3/17/26

I-5719B_U5800_Submittal S-008-4B Plans
MI-Engineering- Hydraulics Review

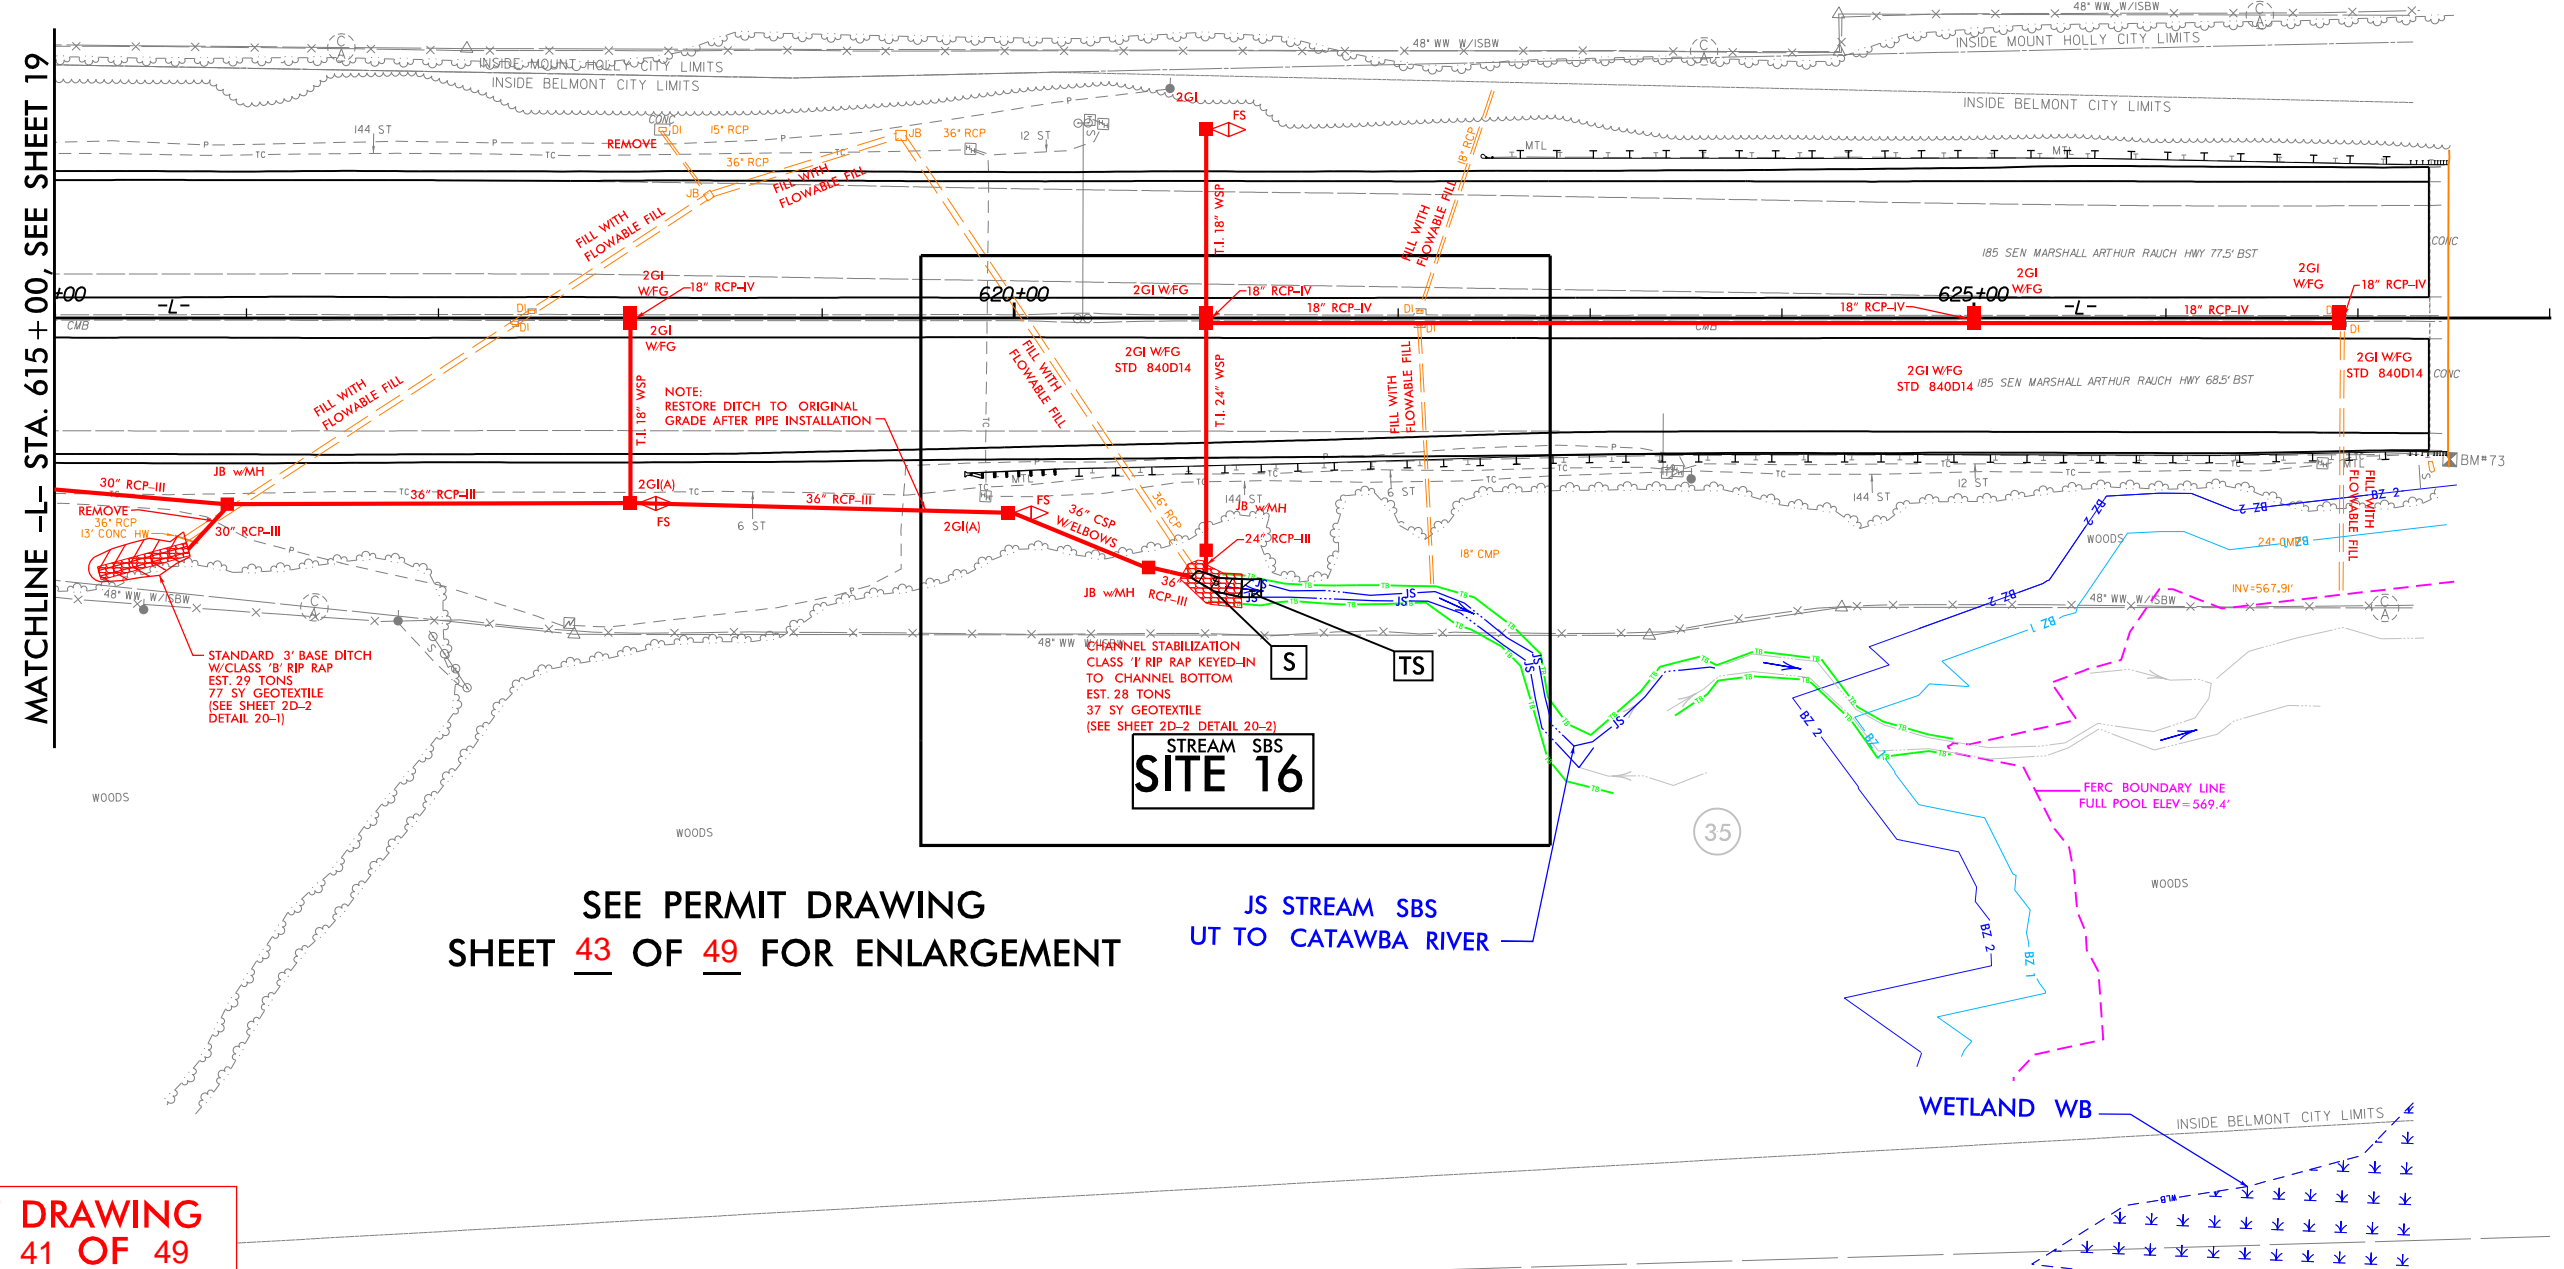
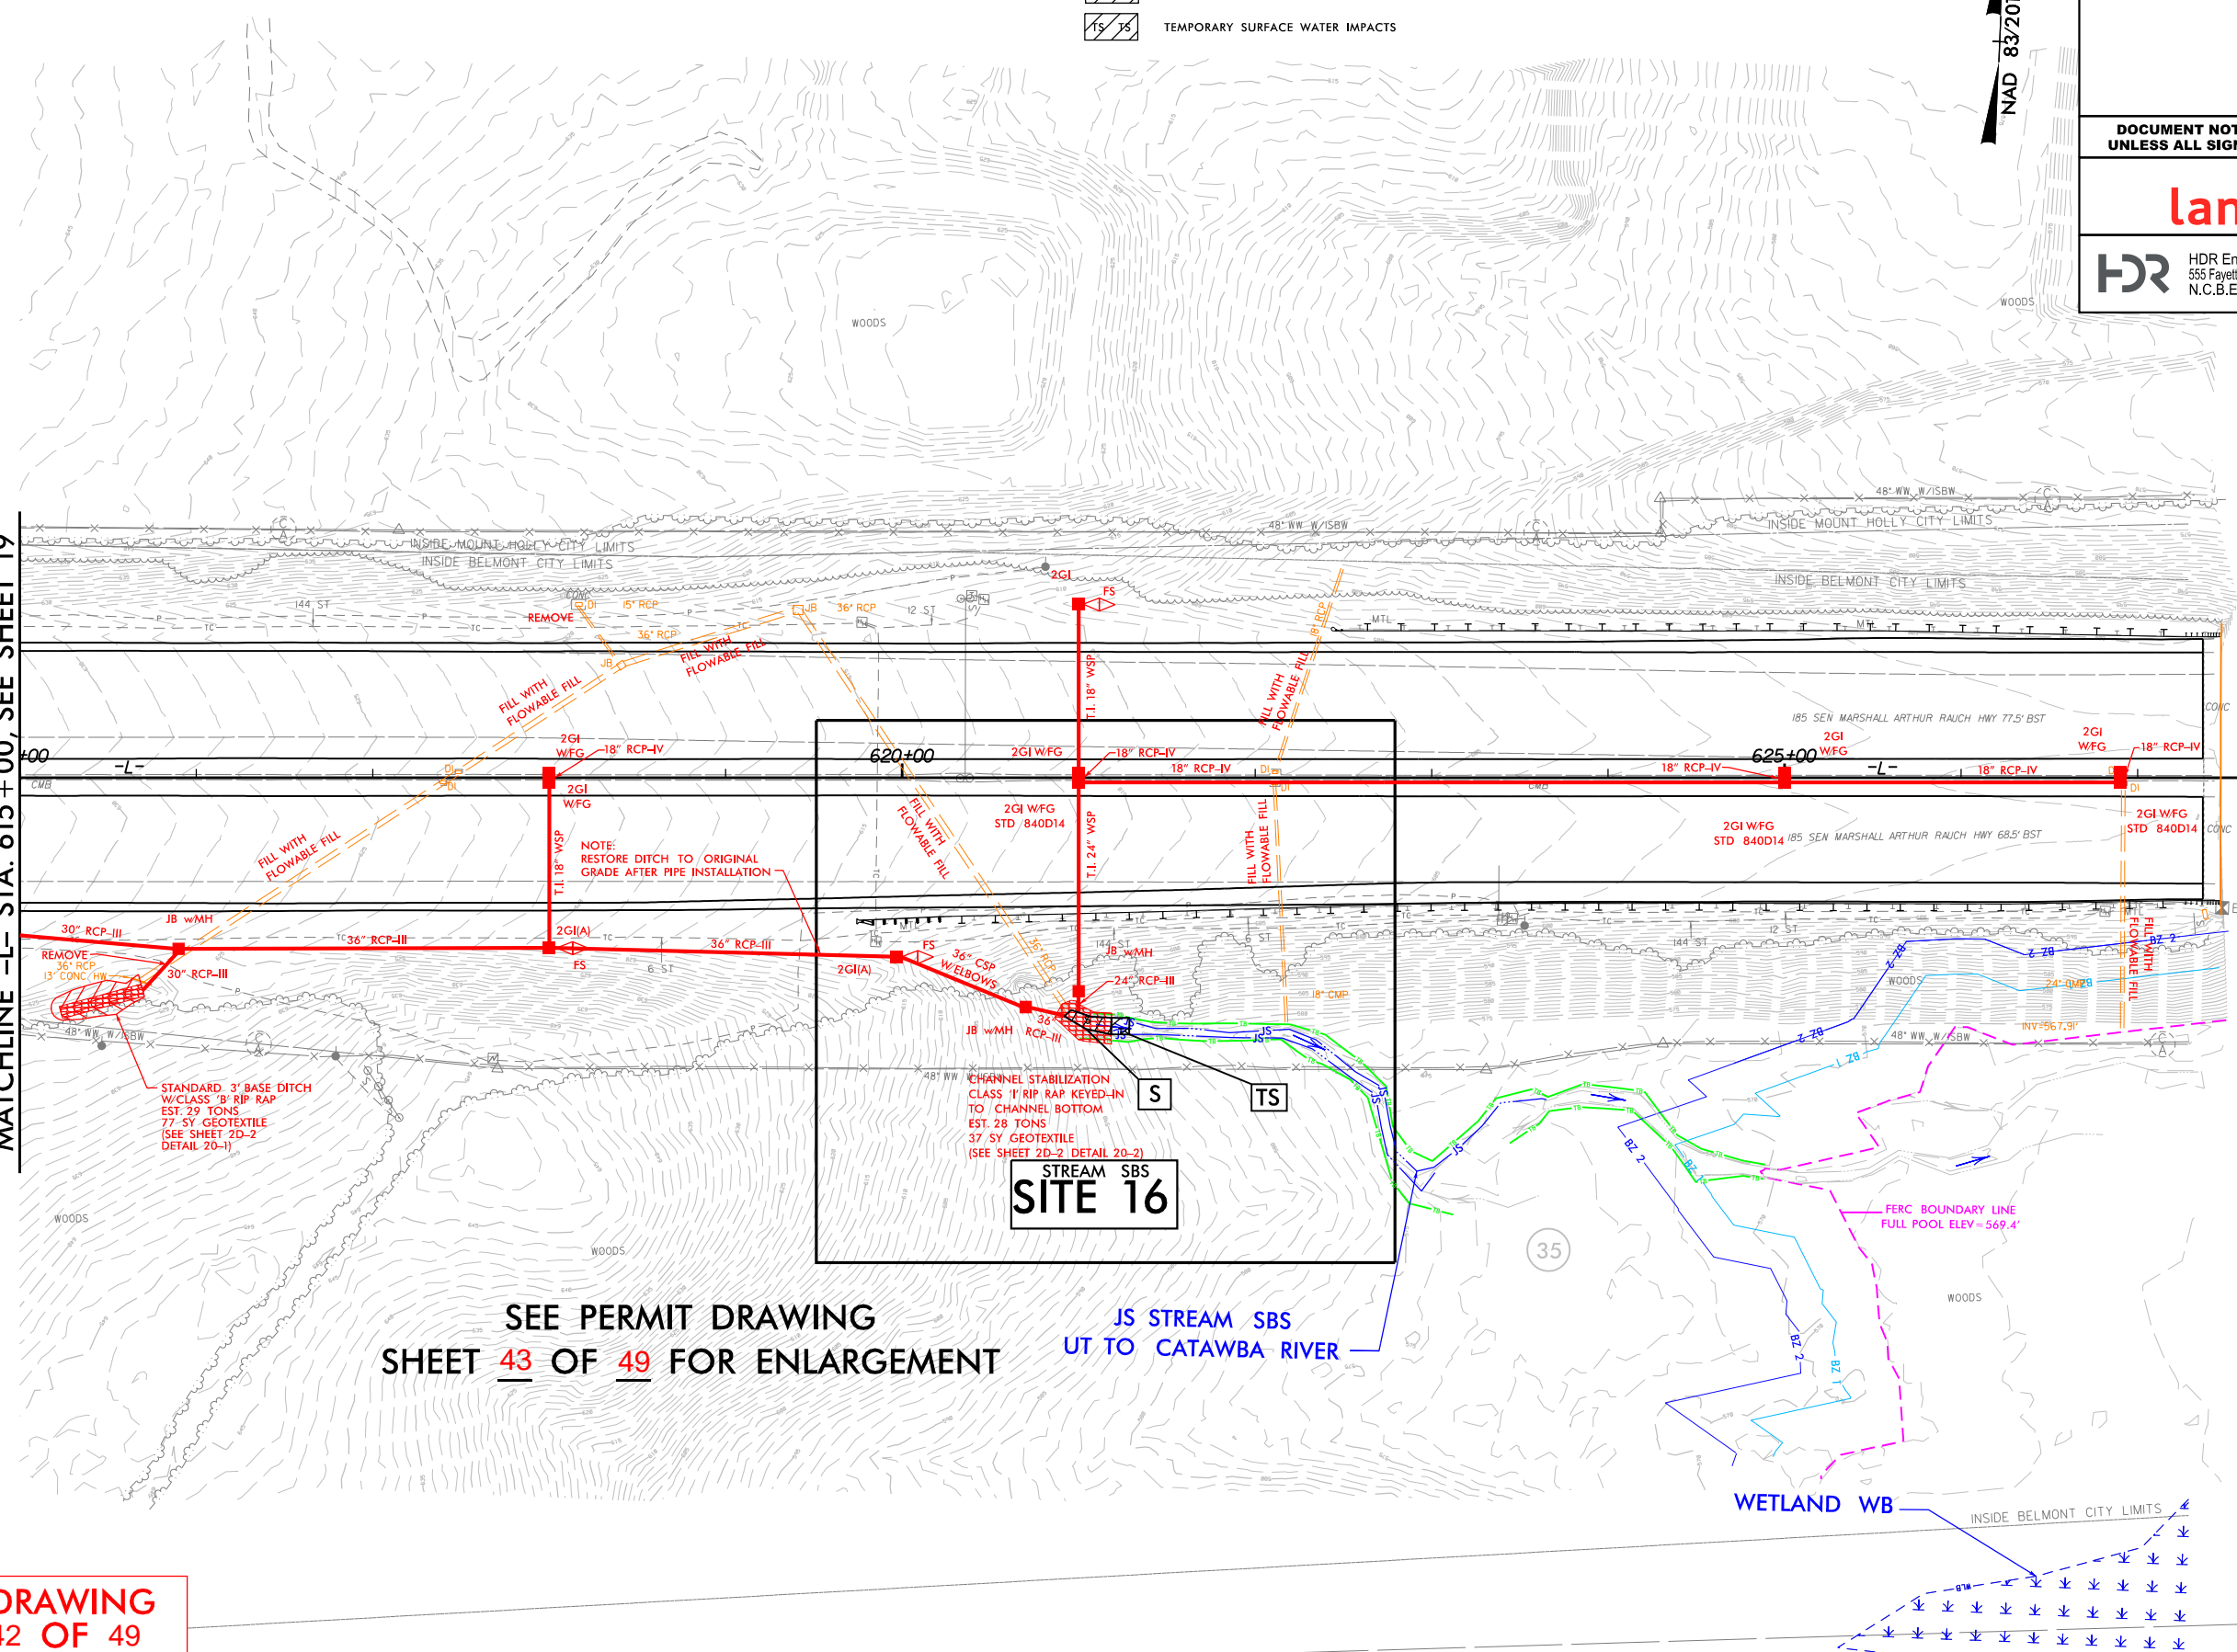
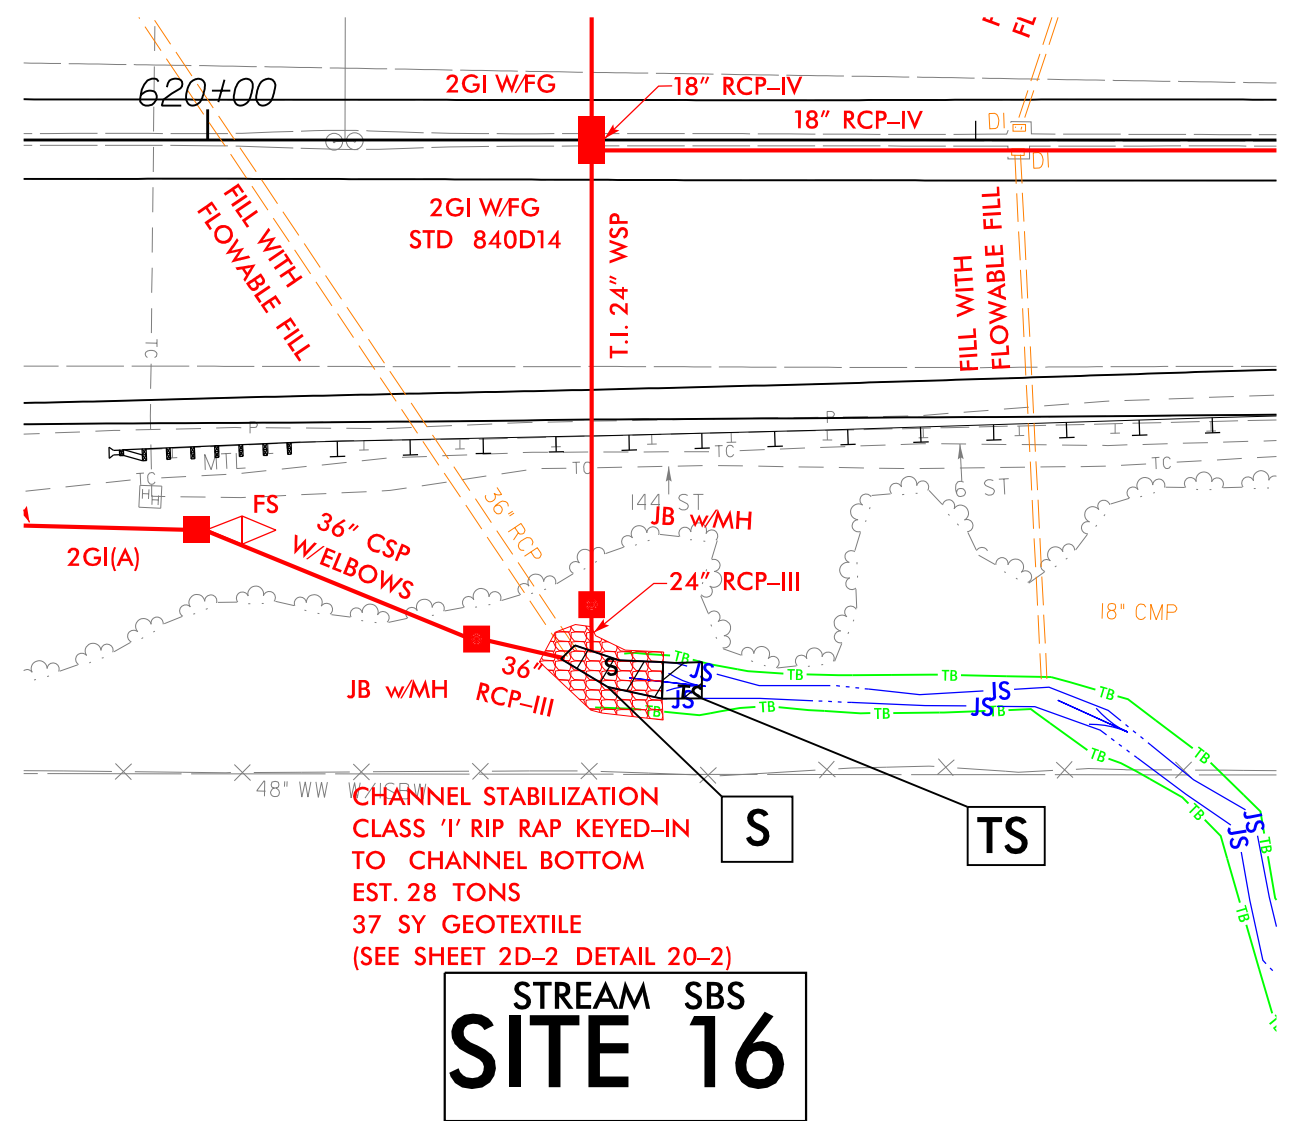
- Outlet channel right of station 621+00 -L-. Recommend lining entire channel with rip rap and not just the banks.
 - Riprap was revised to show key-in to channel bottom.
- Is there a wetland boundary on this sheet right of station 627+00 -L-? There is an easement shown in this location. Is there something going on that would impact the wetland?
 - Easement was removed. Wetland boundary confirmed to be off of this sheet. Wetland symbology removed.

- It appears the Catawba River Buffer zone should be shown on this page. –
 - Buffer zone added to the sheet.

- It appears UT TO CATAWBA RIVER (stream SBS) should be included in PsmP. See impacts plan sheet 20. –
 - The psmP was revised to include stream SBS.
- Were streams evaluated using SELDM tool for recommendations regarding possible stormwater measures needed?
 - They were not. The RFP does not allow for additional ROW for stormwater treatment. We are evaluating areas where grass lined ditches can be provided as well as detention in the Y7 interchange to provide treatment prior to outfalls.
